# **MORGAN AND MORECAMBE OFFSHORE WIND FARMS: TRANSMISSION ASSETS**

**Applicants' Response to South Ribble Borough Council Local Impact Report**

**Deadline: Deadline 3**  
**Application Reference: EN020028**

**7 July 2025**

Figure 1 : Indicative Cross Section of the River Ribble Crossing (refer to the Onshore Works Plans (APP-154))

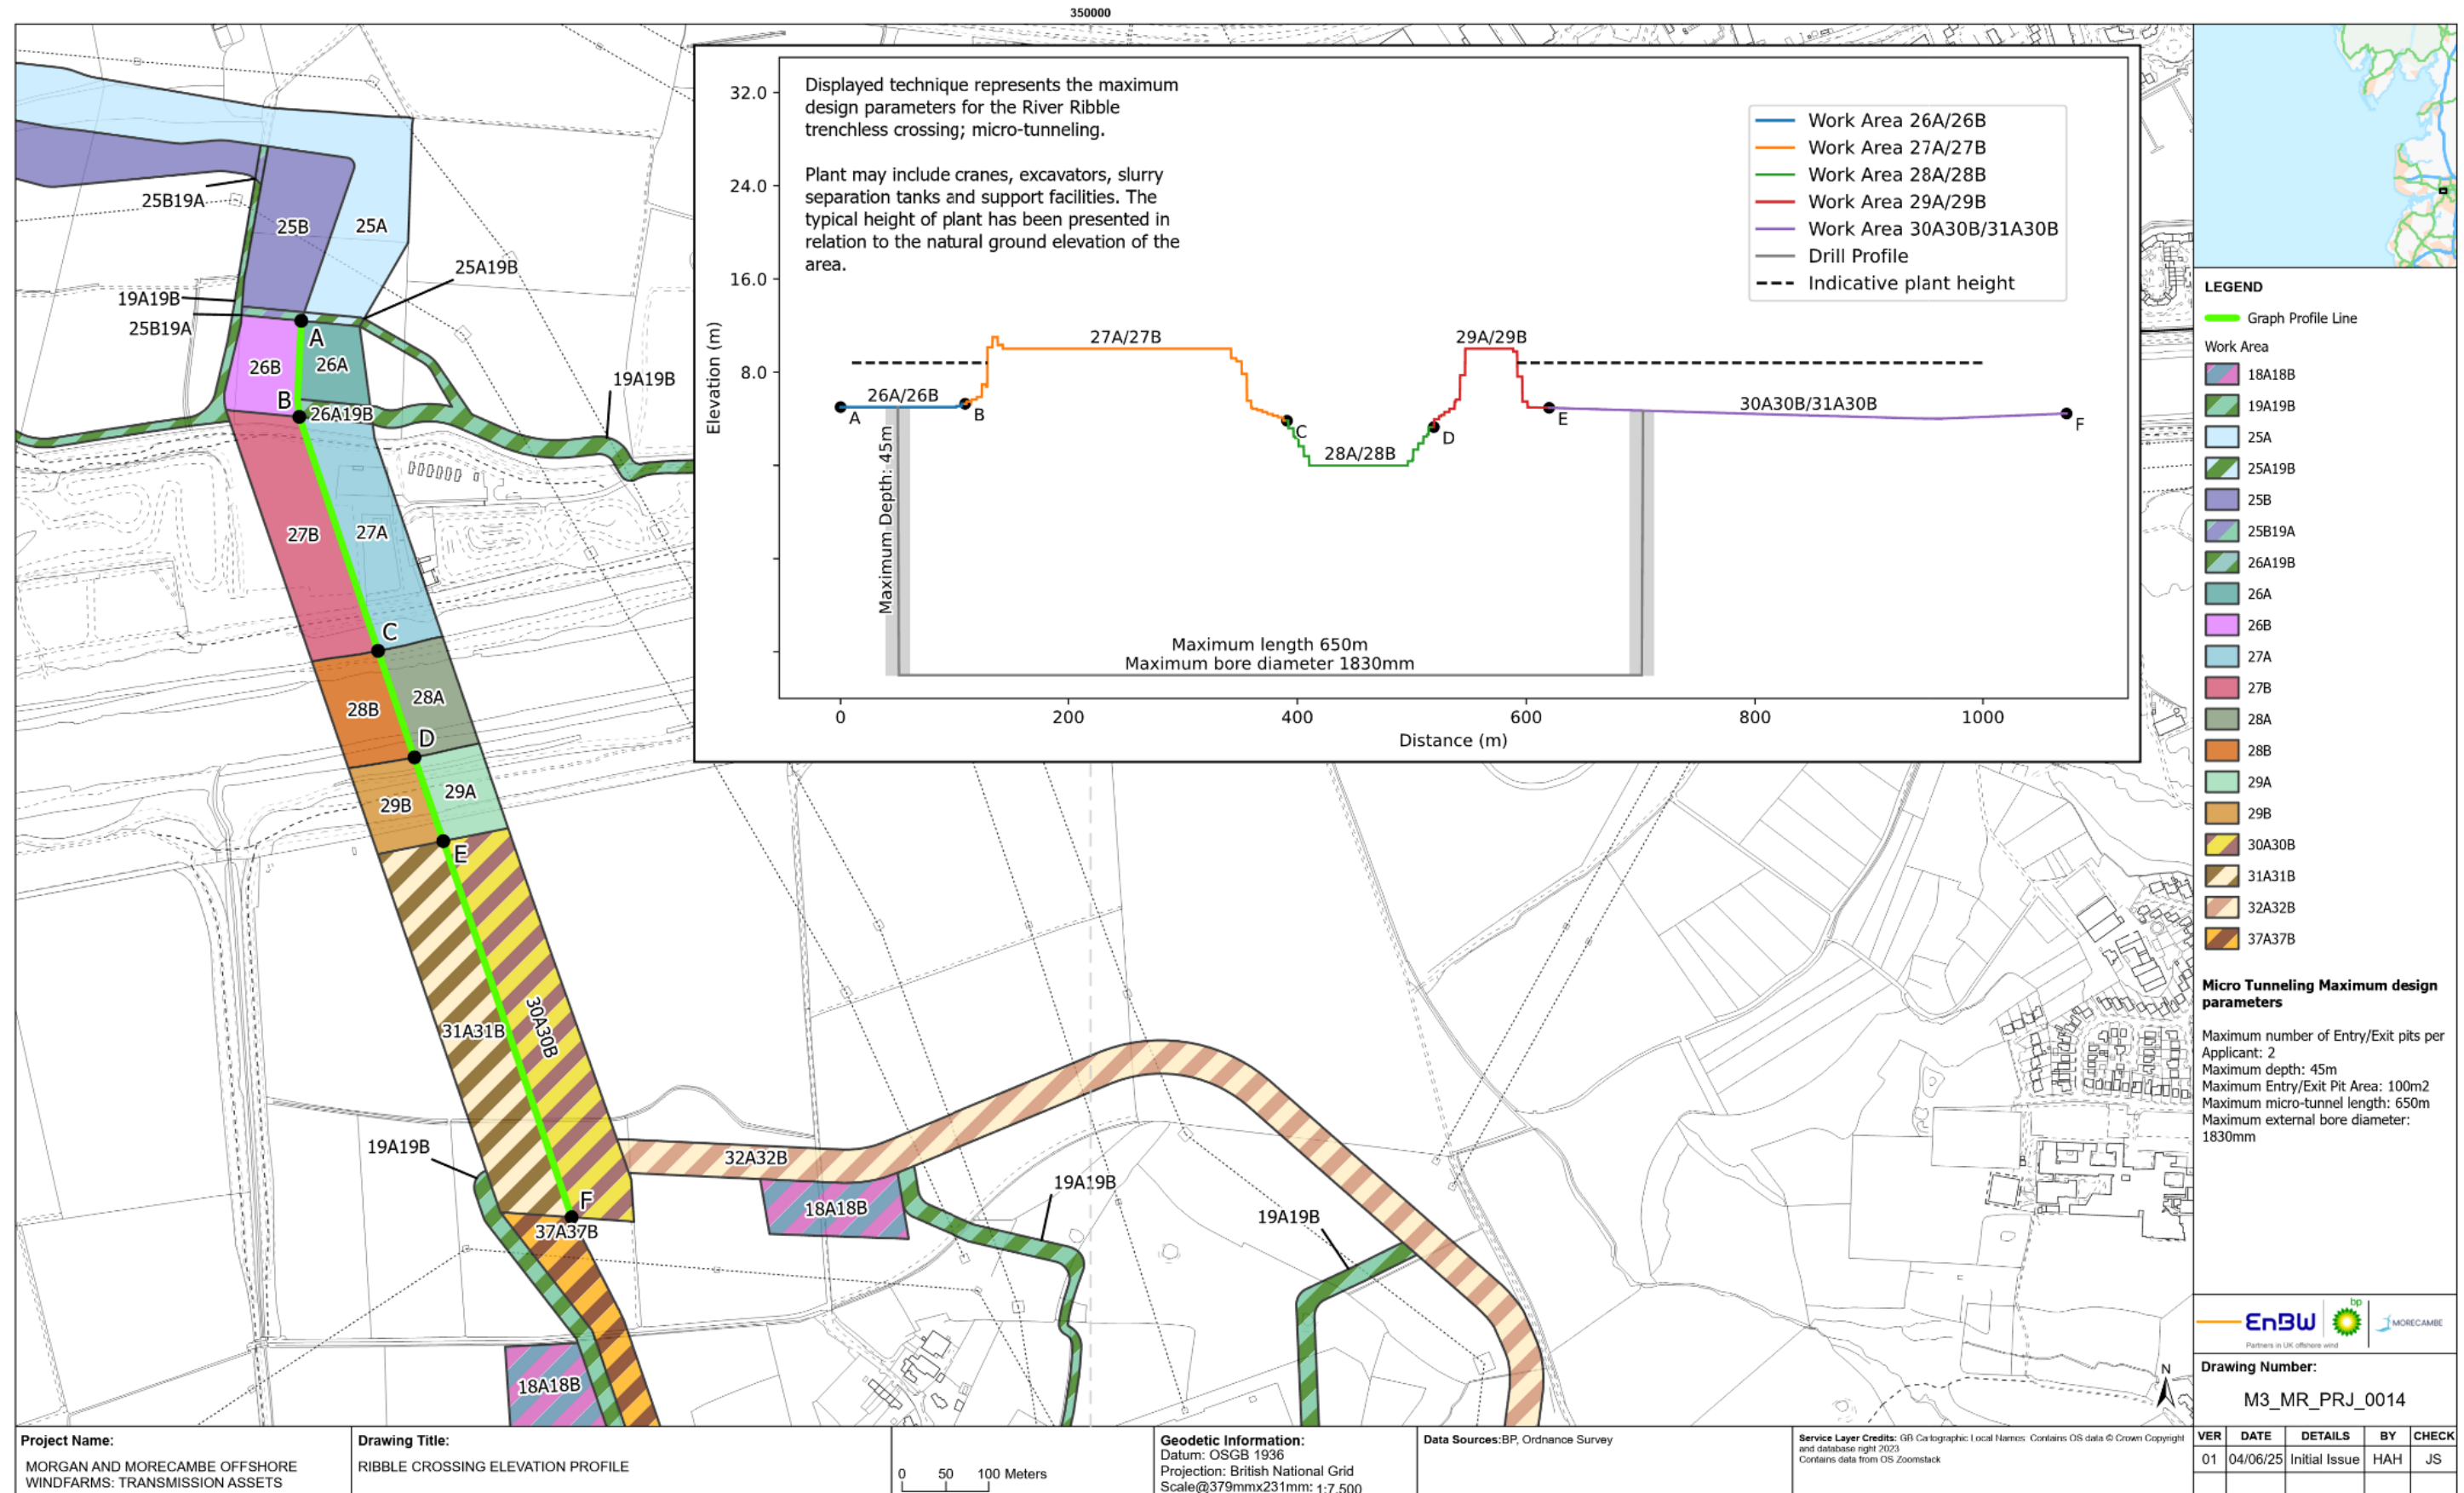
REP1-227 5.16	Additional information was received which confirmed the River Ribble Crossing has identified (see Figure 3.8 and Inset 4 – Figure 3.19, Volume 1: Figures) an approximately 150 m temporary working width, and 50 m permanent width. The proposals for installing a conventional underground cable tunnel trenchless installation technique, with tunnel headhouses, has been removed from proposals. The application now includes direct pipe, micro-tunnel trenchless installation techniques within the design envelope. The works are proposed to be bank to bank (i.e. no works will take place in the water) (CoT90 within the Commitments Register in Volume 1, Annex 5.3). As this information was received on the 14th of May 2025, limited time was available for the changes to be assessed by the Council's archaeologist however given the overlapping of temporary works required to the south of the River Ribble to accommodate this method including temporary access, working areas and construction compounds, the	<p>The Applicants refer SRBC to the response to 2027.15 in Procedural deadline A Submission - Annex 3.2.19 to Response to RR – South Ribble Borough Council (RR-2027) (PDA-026). The Applicants met with South Ribble Borough Council on 14 May 2025 and can confirm that at that meeting they directed SRBC to the Transmission Assets application documentation. It is noted that within section 3.7.2 of Volume 1, Chapter 3: Project description (REP2-008) that the temporary working widths for the River Ribble crossing are 150 m and these have not been updated. Further, within the same section it is noted that tunnel headhouses have been removed from the proposal leaving direct pipe and micro-tunnel techniques within the design envelope for the River Ribble crossing.</p> <p>Section 3.10 of Volume 1, Chapter 3: Project description (REP2-008) highlights that there are overlapping temporary works south of the River Ribble including temporary access, temporary working areas, and temporary construction compounds. These temporary works overlap to provide the necessary flexibility regarding connection to the National Grid substation which will be decided by National Grid.</p>
